Document DCO 7.1 / MCO 7.1

Applicant's response to the s51 / 55 advice

FEBRUARY 2026

The East Midlands Gateway Phase 2
and Highway Order 202X and The East Midlands Gateway
Rail Freight and Highway (Amendment) Order 202X

# ES Chapter Study Area Figure (Core Assessment)

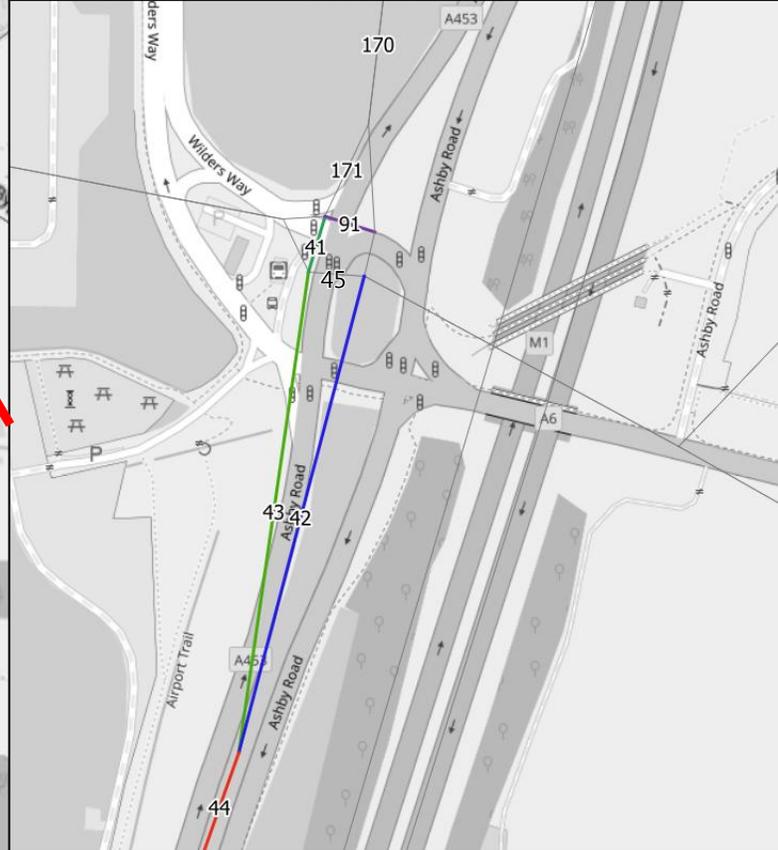
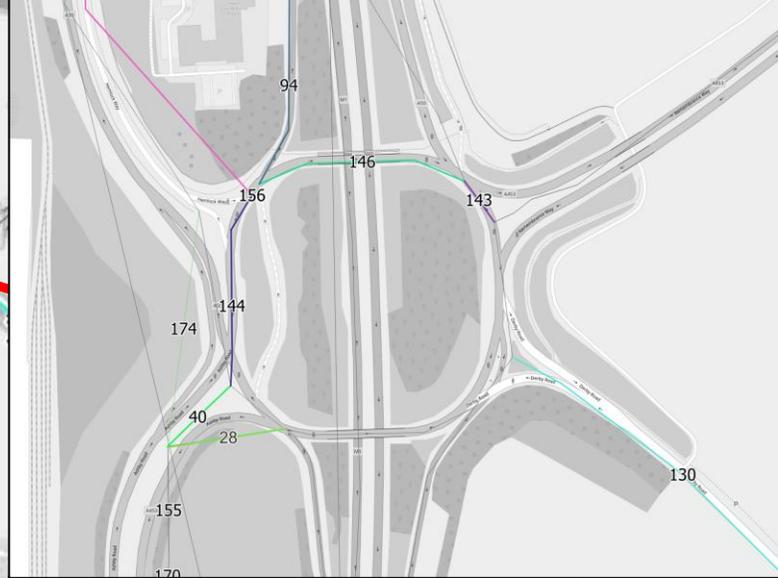
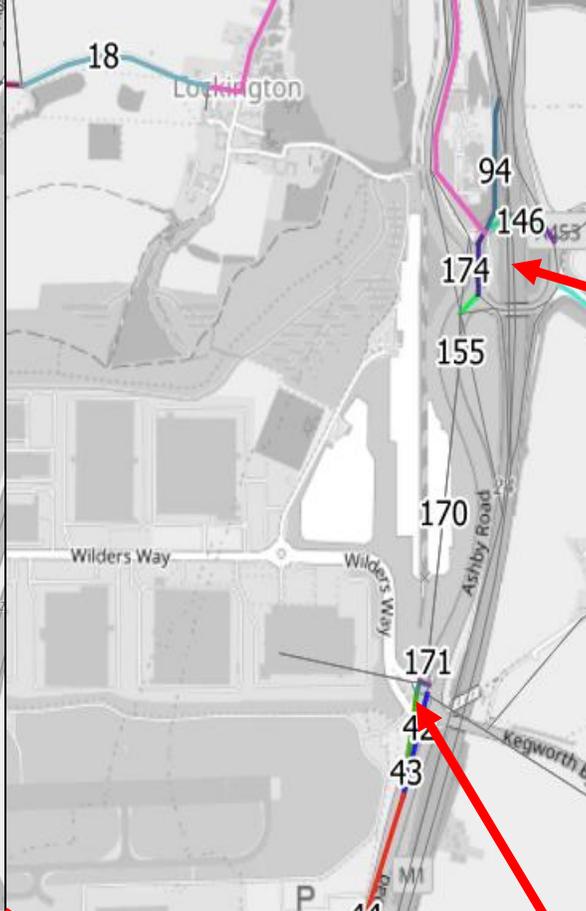
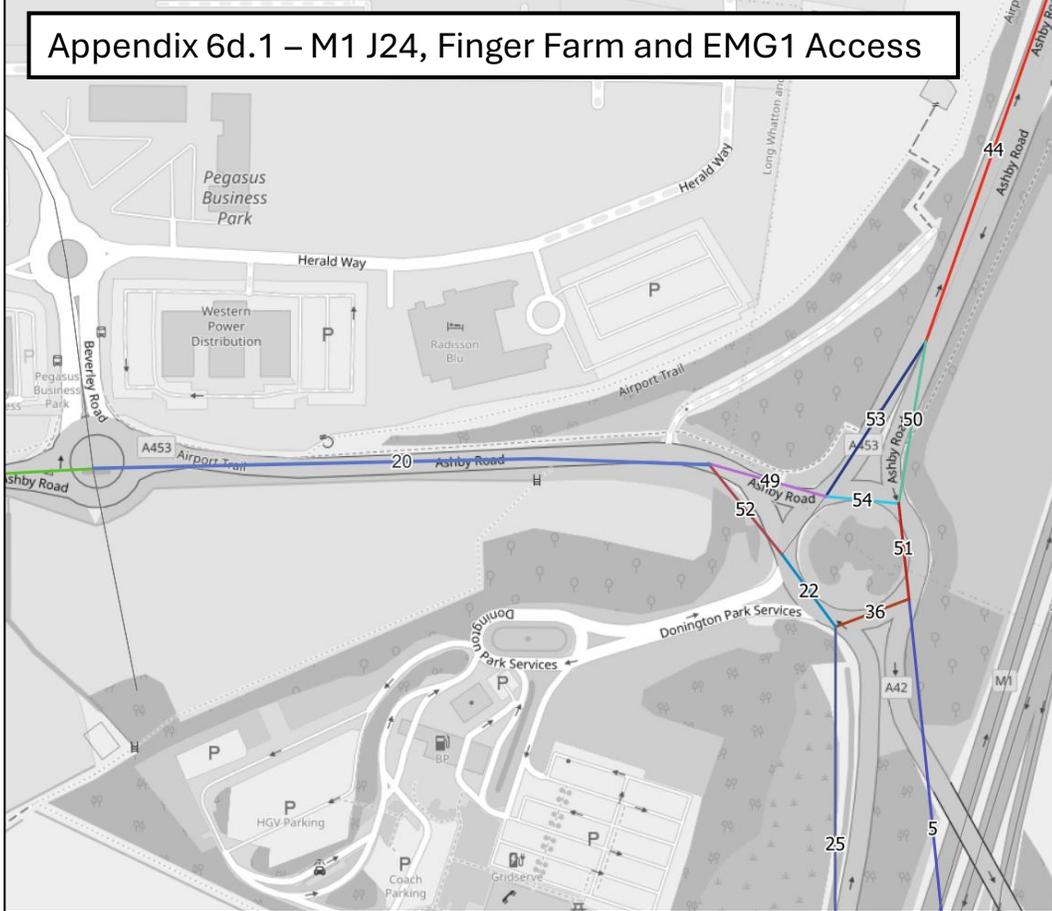
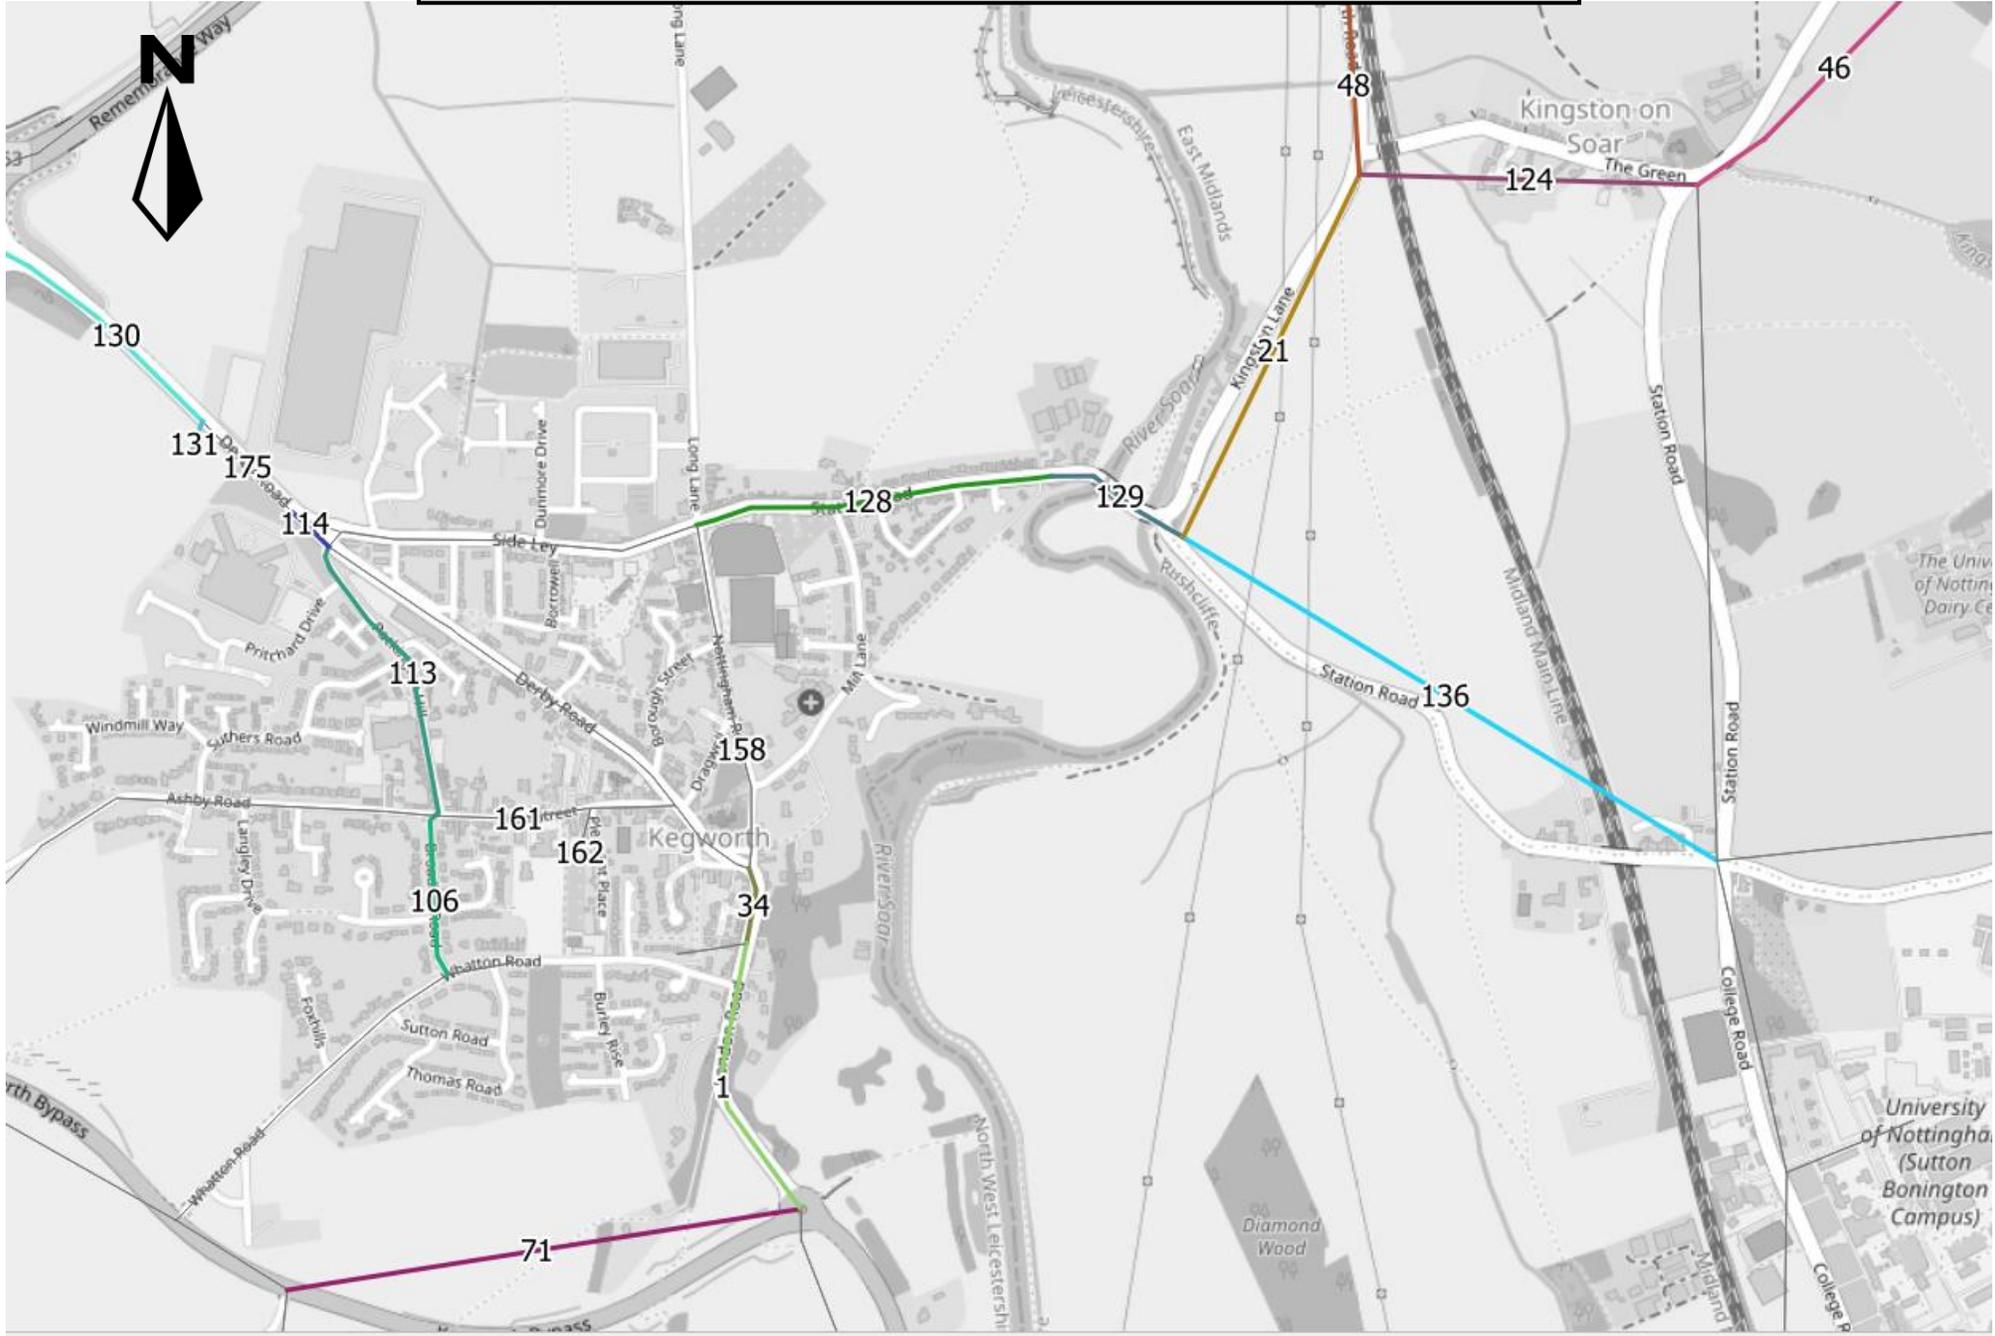
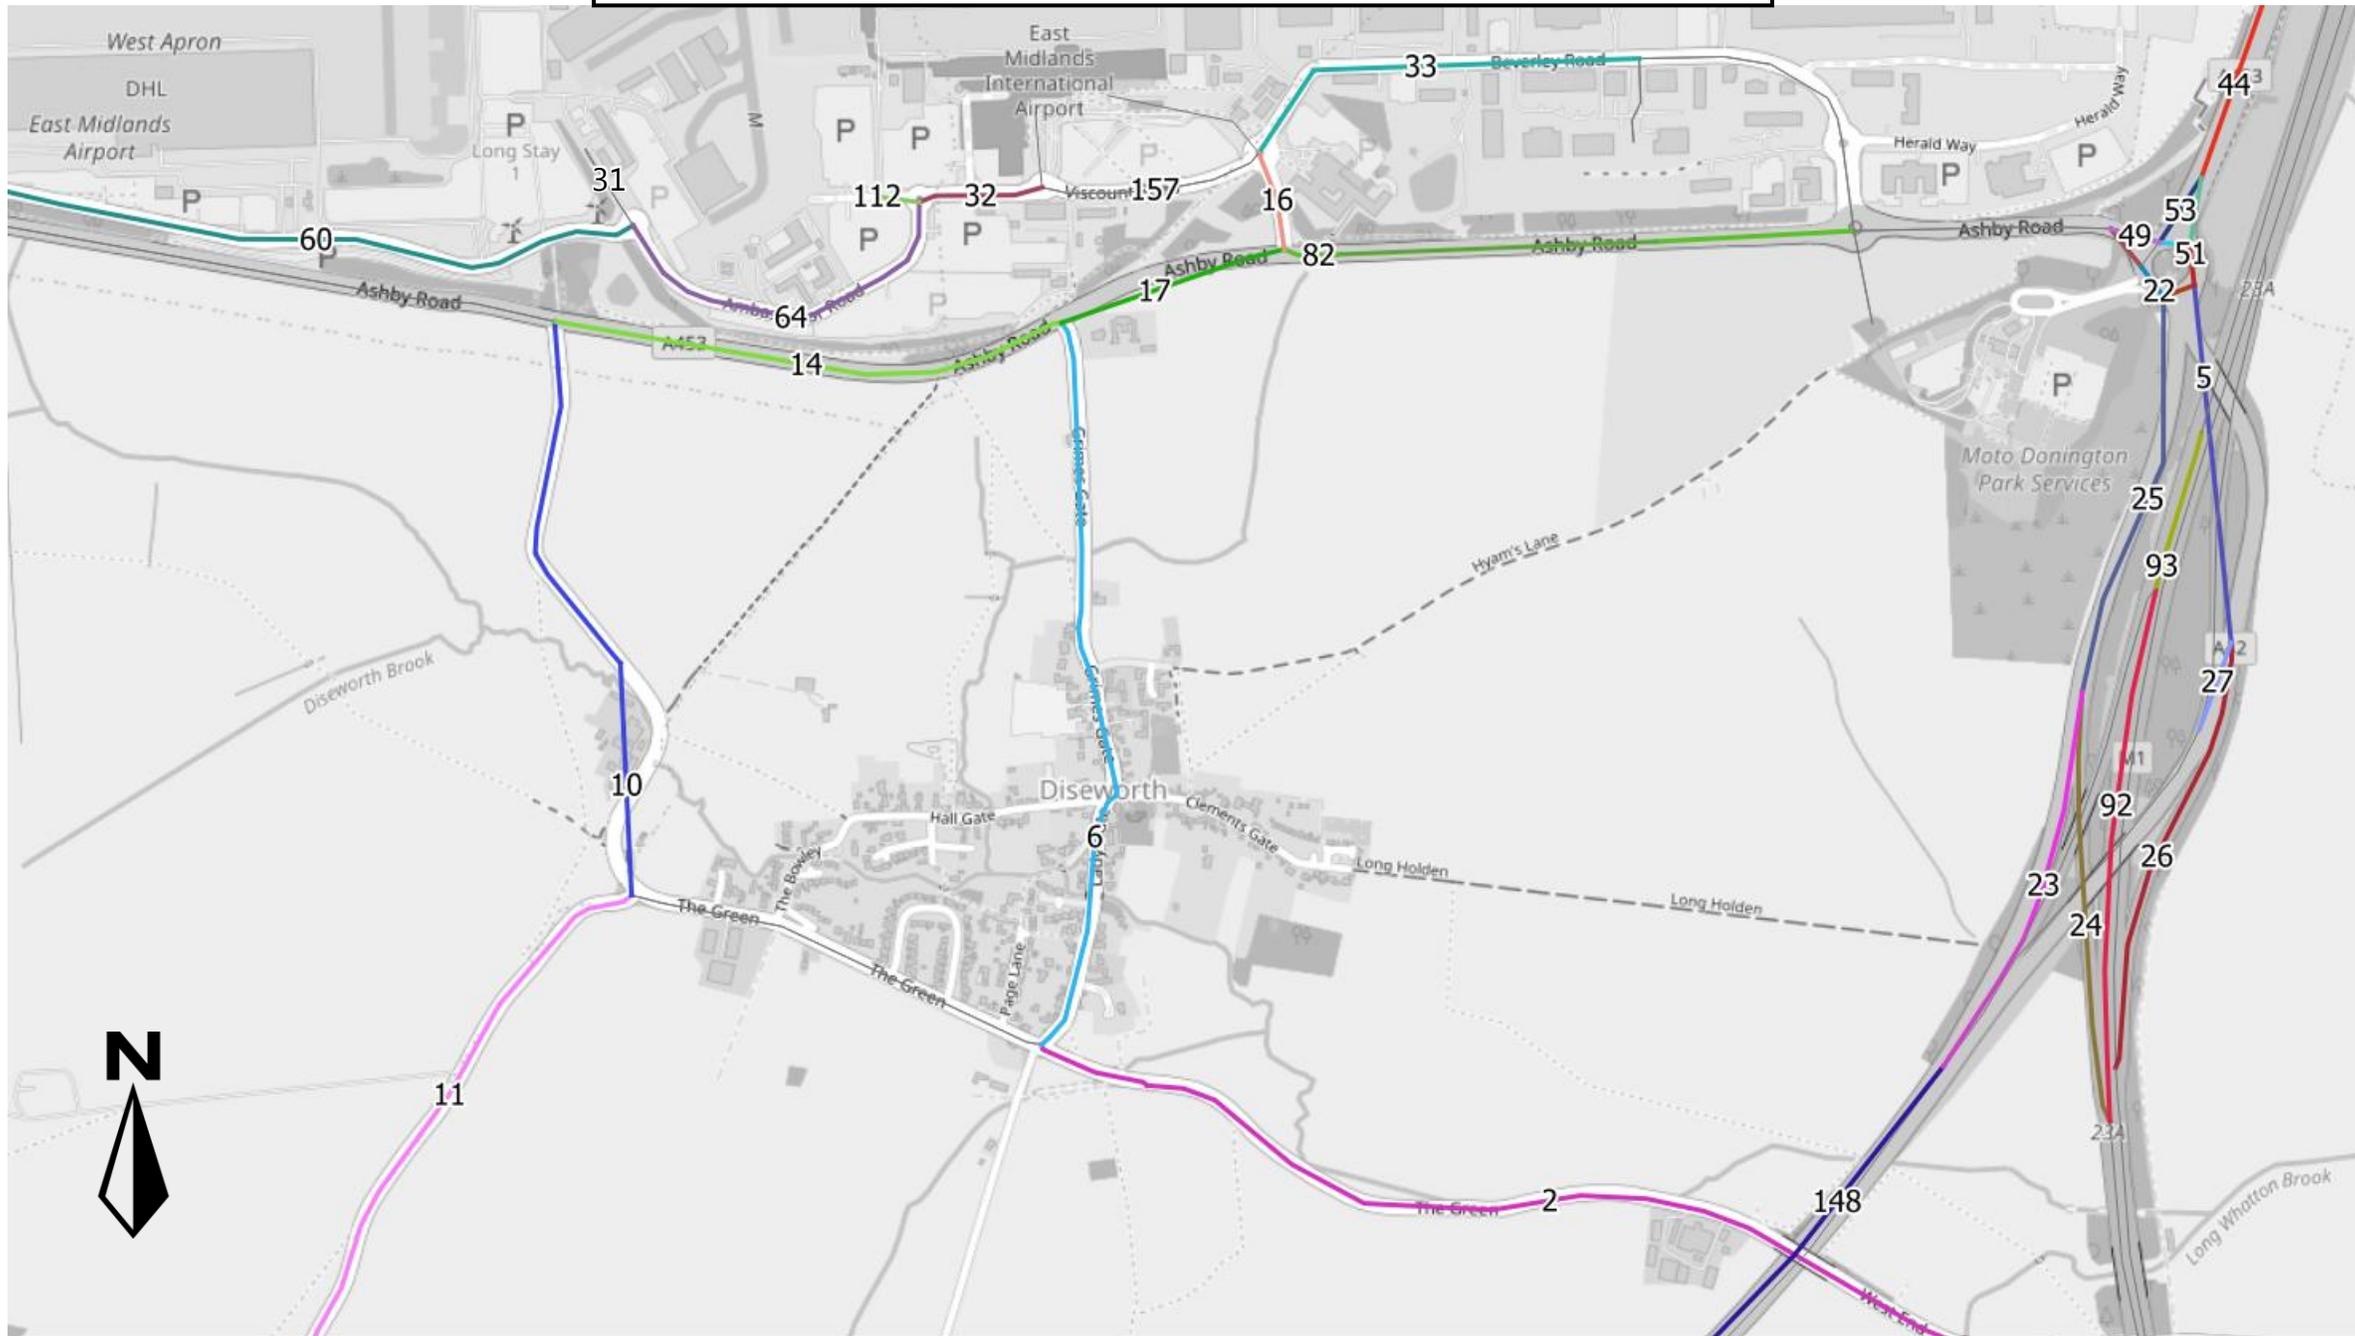
36.	i. Check and correct the description of highways links 141 and 145, described as Kegworth bypass but shown in Castle Donnington, in Chapter 6 tables 6.9 and 6.14 and Appendix 6.6D	Environmental Statement	6.6 and 6.6D	The tables in Chapter 6 and Appendix 6.6D have been corrected.

37.	ii. The links listed in the s55 comments are numbered in tables 6.9 and 6.14 but not shown at all or clearly in Appendix 6.6D	Environmental Statement	6.6 and 6.6D	Appendix 6.6D has been updated. The table at Appendix 4 lists all of the links identified and provides a cross reference to the figure depicting the relevant link.
